REPORT UPDATE

Application No: R/174/14/HH

Recommendation Report for Planning Permission for Works or Extension to a Dwelling

PROPOSAL: Demolition of existing conservatory together with existing roof removal to construct a new chalet style loft conversion with new pitched roof with dormers.

A	PLANNING SUBMISSION (MAY14)
-	AMENDMENTS
NEW 32 BROADMARK LANE, RUSTINGTON, WEST SUSSEX BN16 2JA FOR MR & MRS. D. JACKSON	
SCALE @ A2 1:100	
DRAWING NO 2014/05/1002

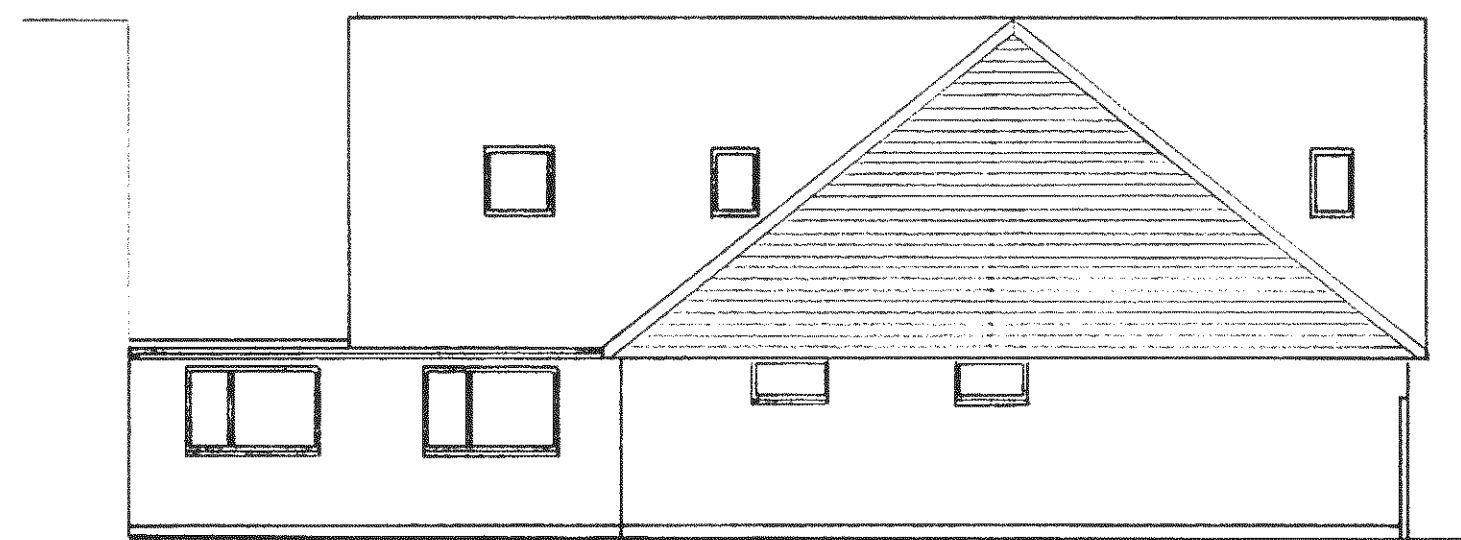
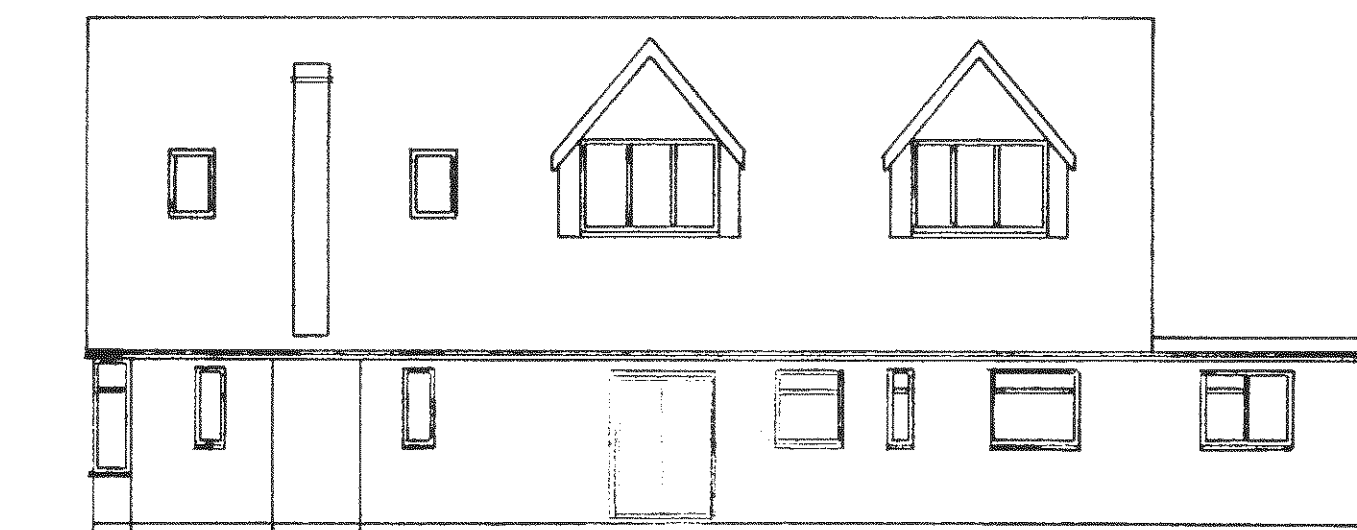
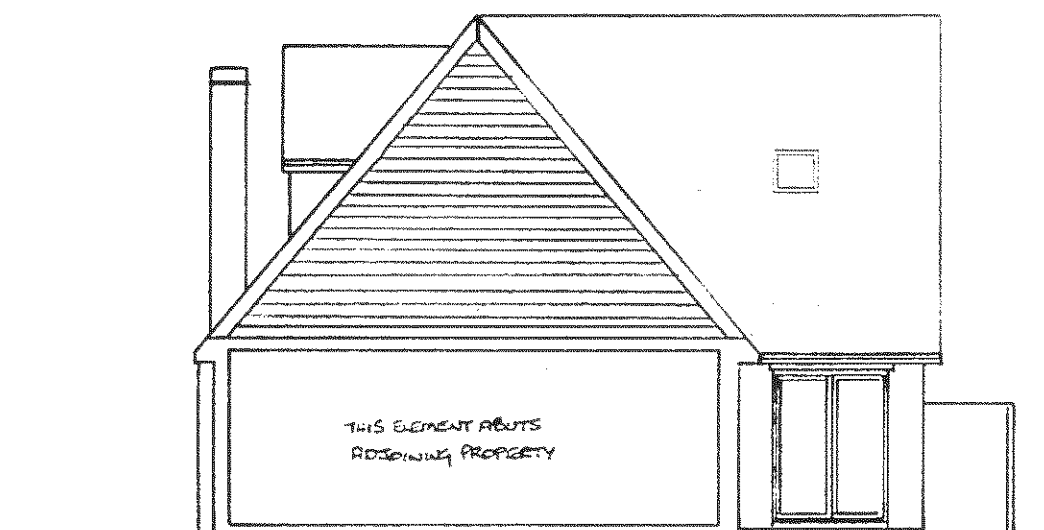
As above. The existing hipped roofing will be removed and replaced by gable roofing which will be raised in height in order to accommodate first floor living space. Two dormer windows will be installed within the northern slope of the replacement roof. The ridge height of the new roof will be approximately 6.8 metres, the eaves height will remain as existing.

The proposal will not maintain visual subservience towards the existing dwelling as it will involve raising the overall height of the majority of the existing building. However, it is considered that the height increase is not excessive, and that the new roof line will appear balanced. By incorporating various additions that have been made to the original dwelling it will lead to a more visually coherent appearance to the dwelling than is currently the case. The proposed dormers within the northern slope of the new roof are modestly sized and, as such, will not overwhelm it.

The proposed dormer windows will look towards the road and the front windows of properties on the other side of the road are considered to be a sufficient distance away to prevent invasive views. All other first floor windows will be in the form of roof lights which will be angled upwards and, in any case, will face towards either the road or the elevation walls of neighbouring dwellings. No new ground floor windows will be formed. It is therefore considered that the proposal will not result in any intrusive levels of overlooking towards neighbouring residential property.
